From: Contact Centre (CRM) <contact@ribblevalley.gov.uk>
Sent: 04 July 2023 12:26
To: Planning
Subject: Planning Application Comments - 3/2023/0436 FS-Case-528958996

Planning Application Reference No.: 3/2023/0436

Address of Development: Woodfold Park Stud, Further Lane, Mellor.

Proposed Site Plan

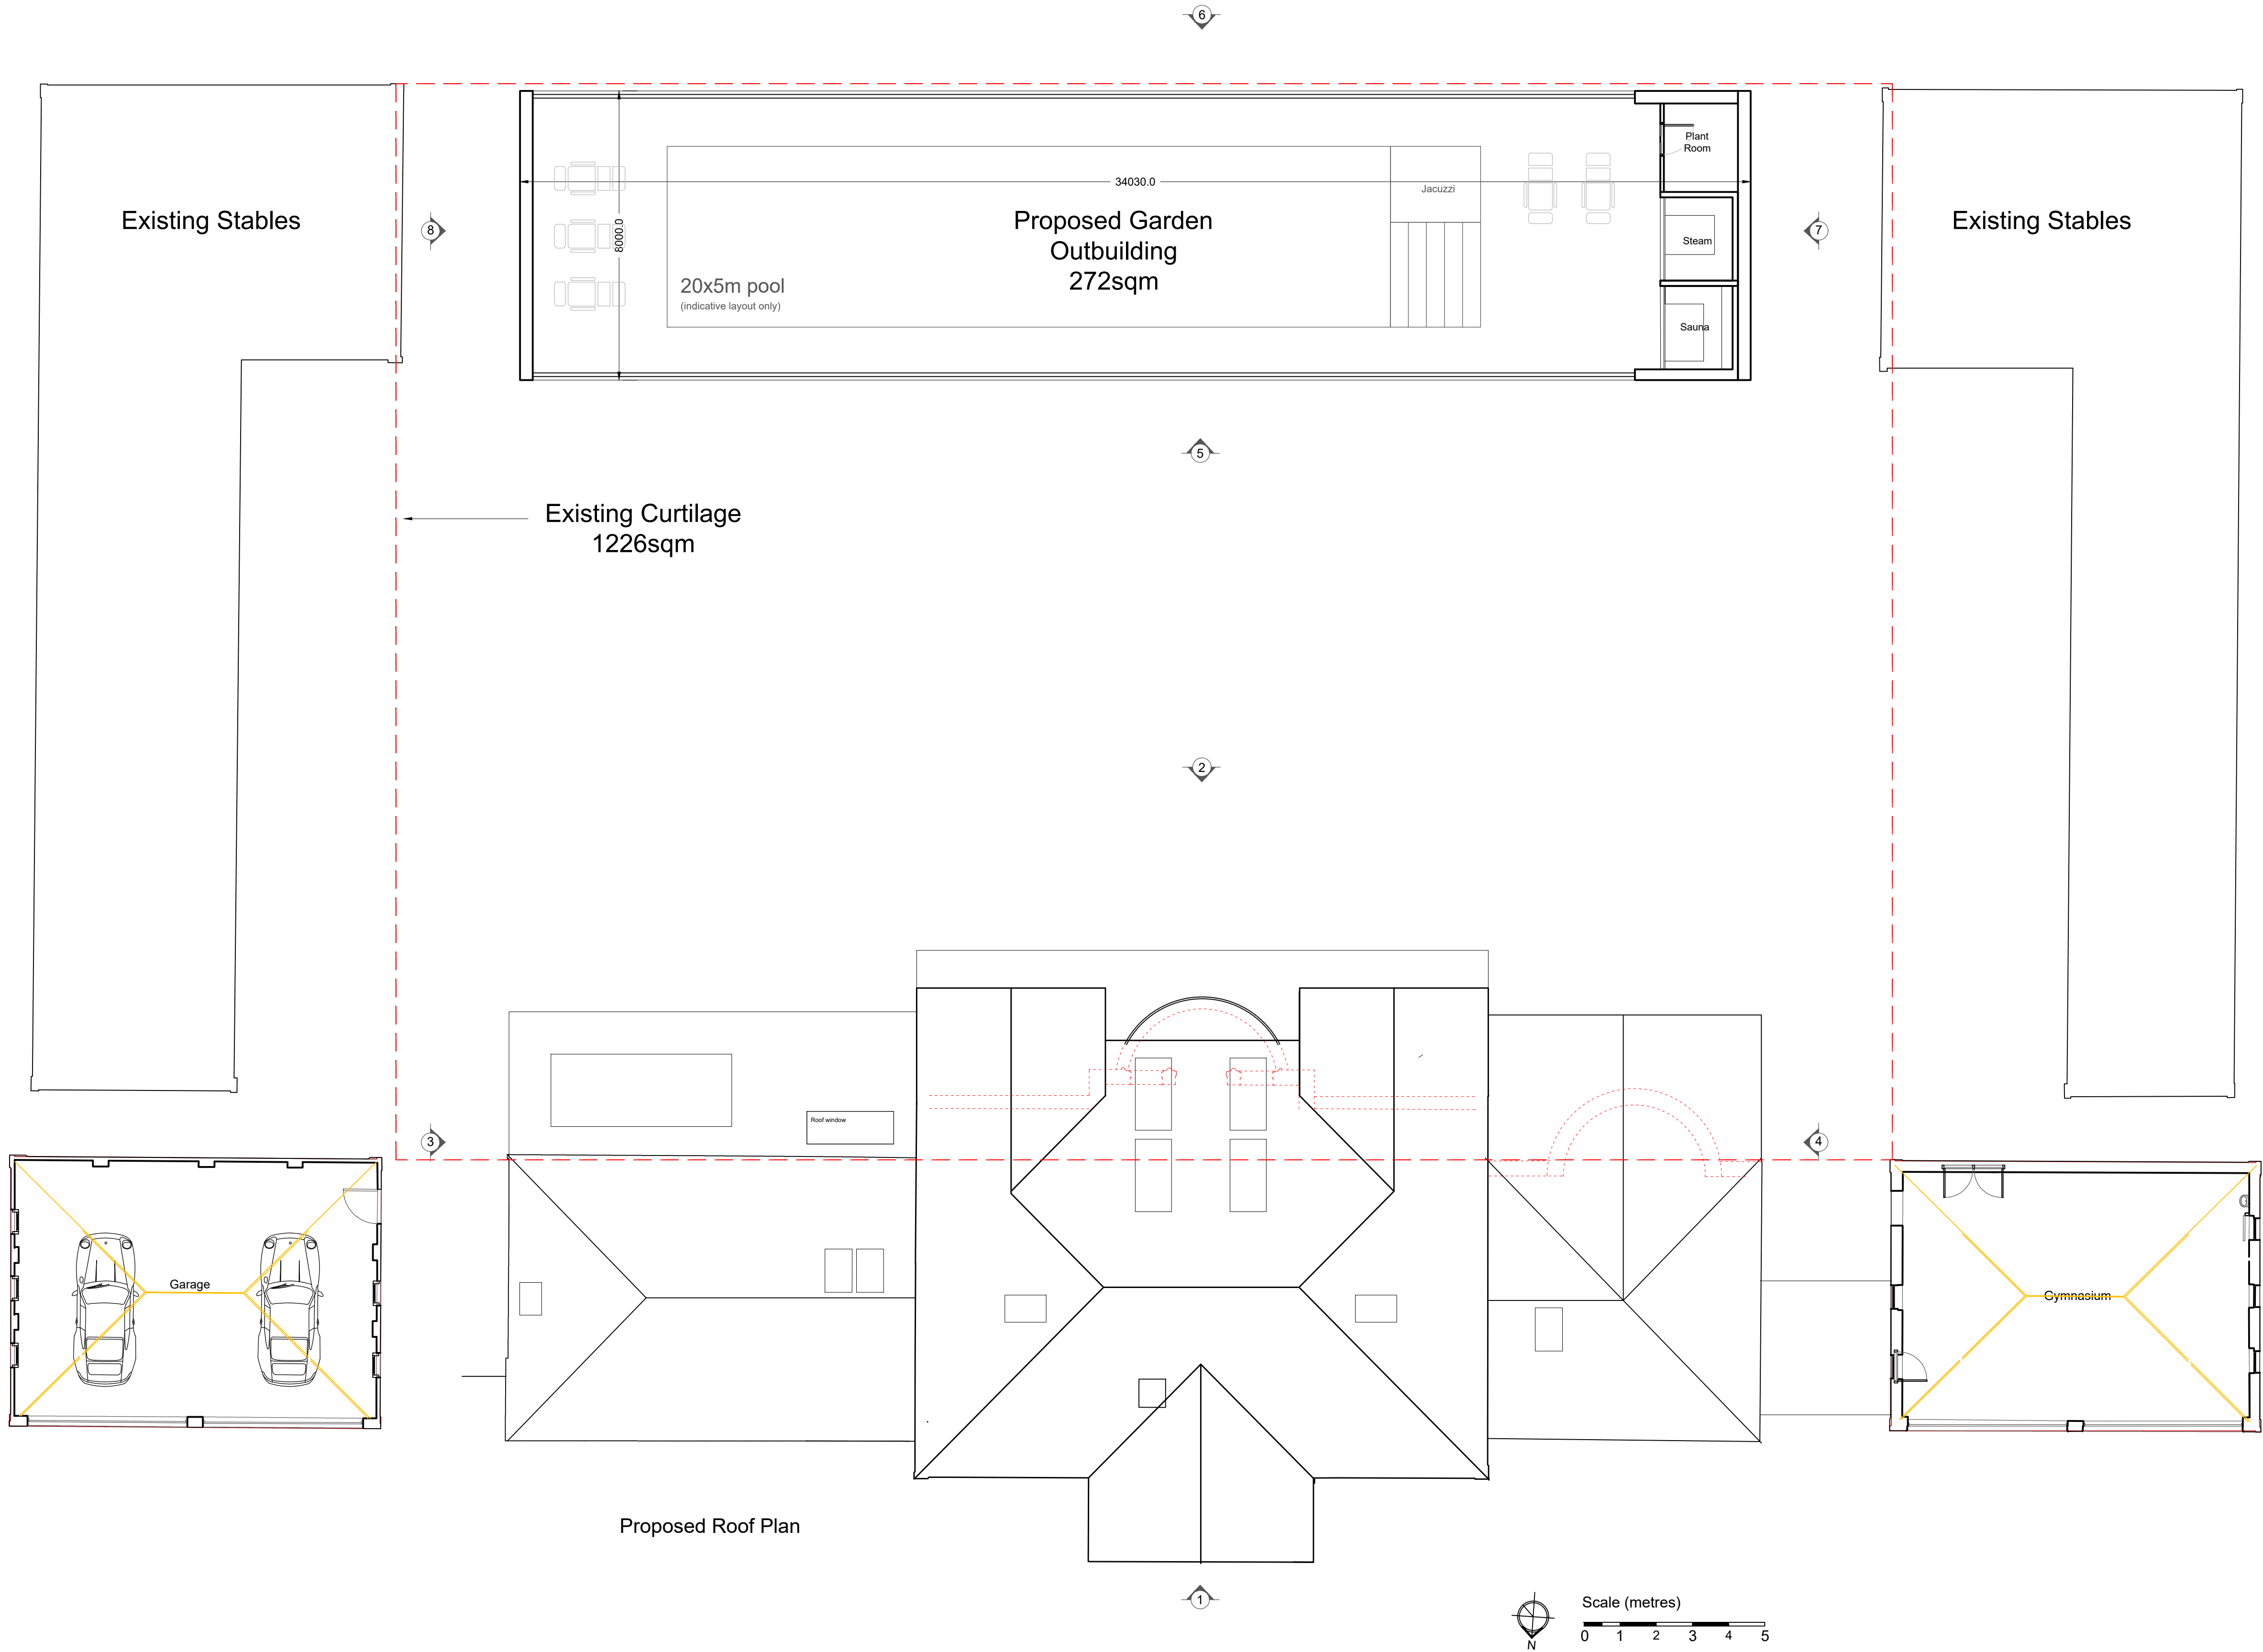
Secondly, the construction of a 5 metre x 20 metre swimming pool (as outlined on the proposed site plan) would probably add additional strain on our existing water supply? Over the past six months our household water has been [REDACTED] requiring remedial action to be carried out by United Utilities.

Assuming the proposed pool would have an average depth of 2.5 metres. Equating to an overall volume of 250 cubic metres which would require 250,000 litres of water to fill. Greater than the capacity of a six wheeler tanker! Additional topping up to account for cleaning / evaporation etc being required throughout the lifetime of the facility. I'm concerned that the additional water demand required will put additional strain on an already "creaky" system. Please can you ensure that United utilities are consulted on this matter?
